Subject: FW: WSCC Planning Consultations on AL/116/18/PL and AL/117/18/PL

DATE 10/16		REV D	
DRAWING EW		SP01	
215818		DRAWING NUMBER	
C/No.		SCALE	
0/No.		1/500 @ A2	
PROPOSED SITE PLAN CHICHESTER LAND AT FONTWELL AVENUE SITE MR DUGGIN FOR SCANDIA-HUS BUSINESS PARK FELCOURT ROAD, FELCOURT, EAST GRINSTEAD, WEST SUSSEX, RH19 2LP : TEL 01342 838060 scandiahus

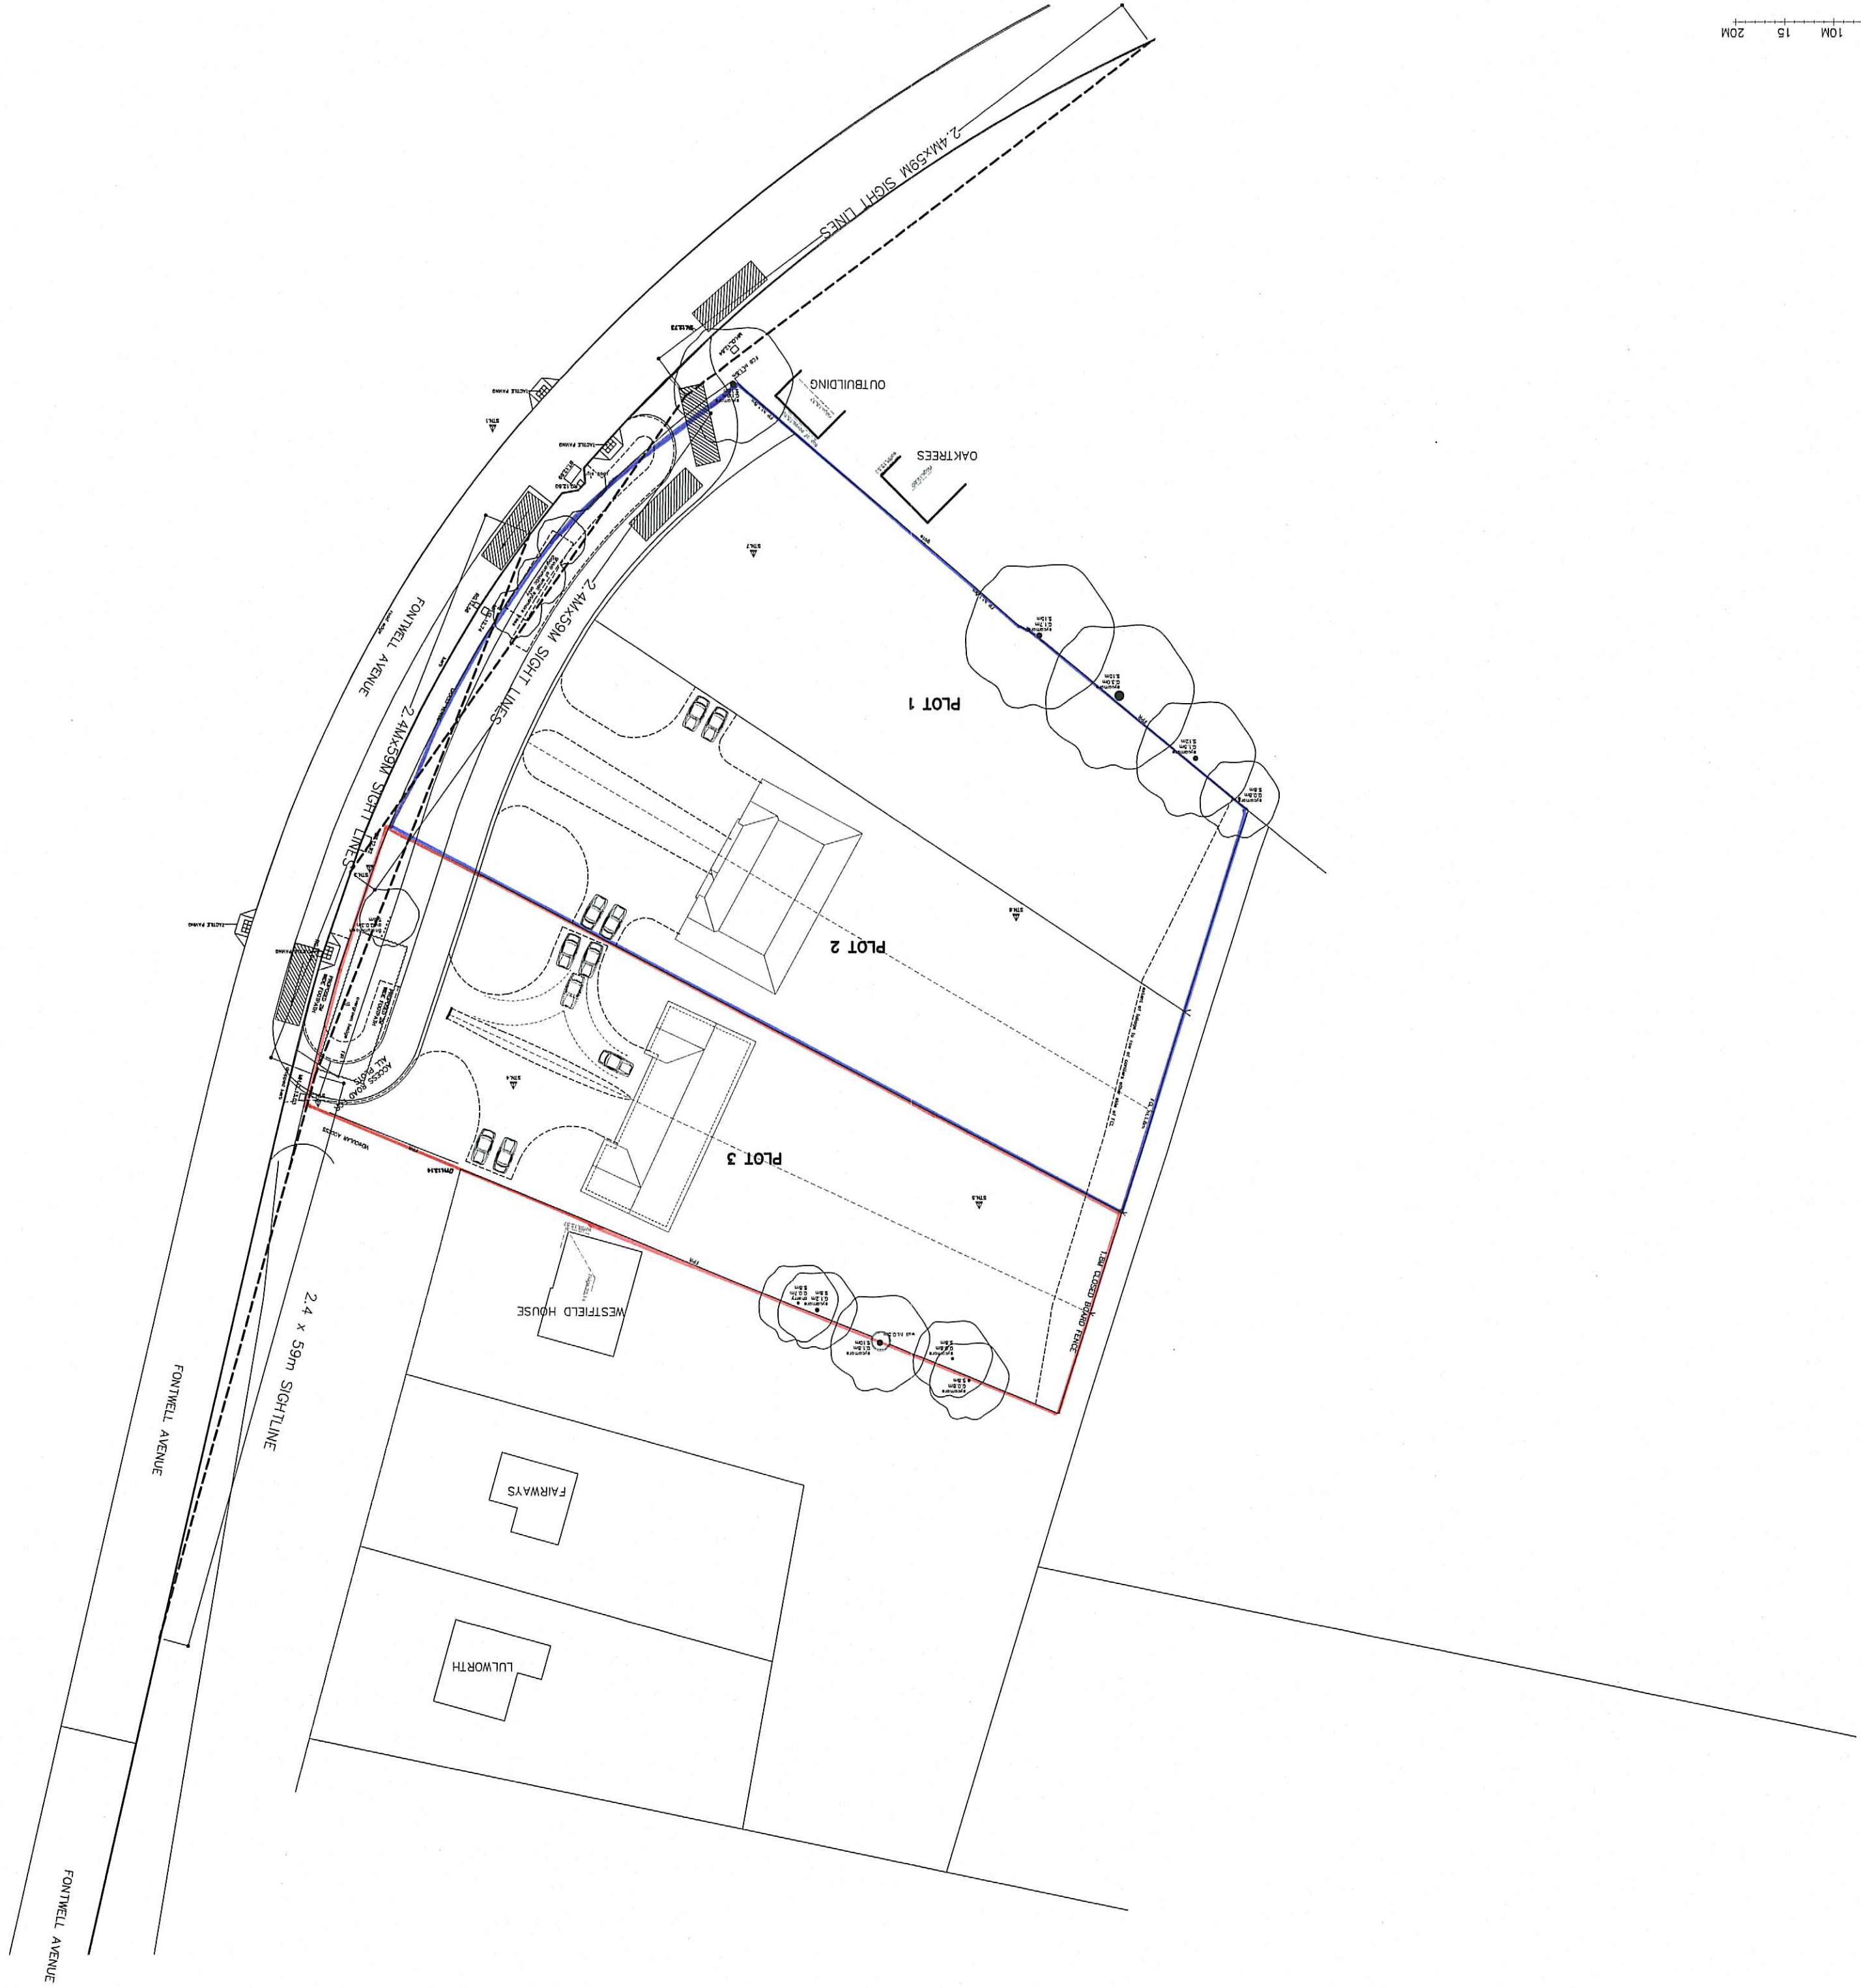
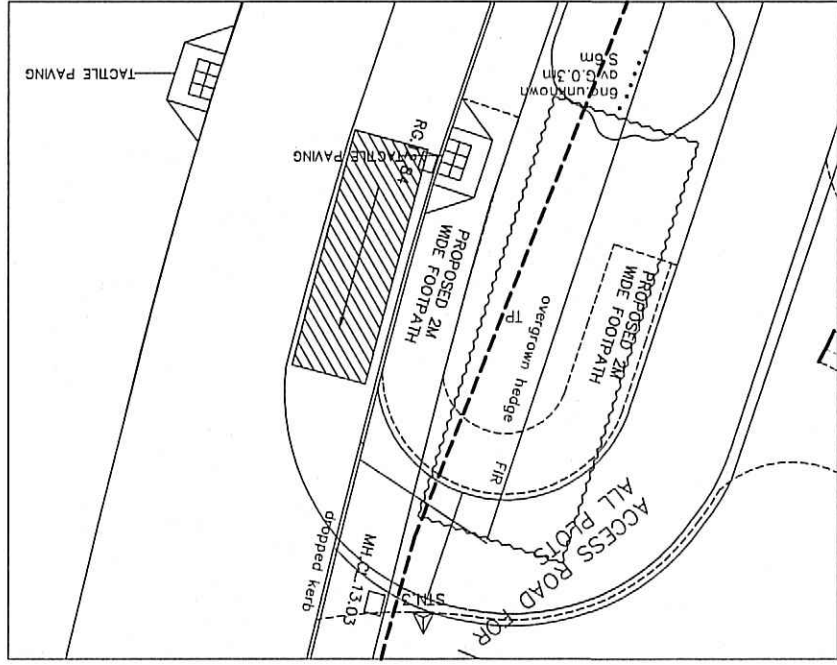
Please see further advice from Highways below and therefore please provide further amended drawings.
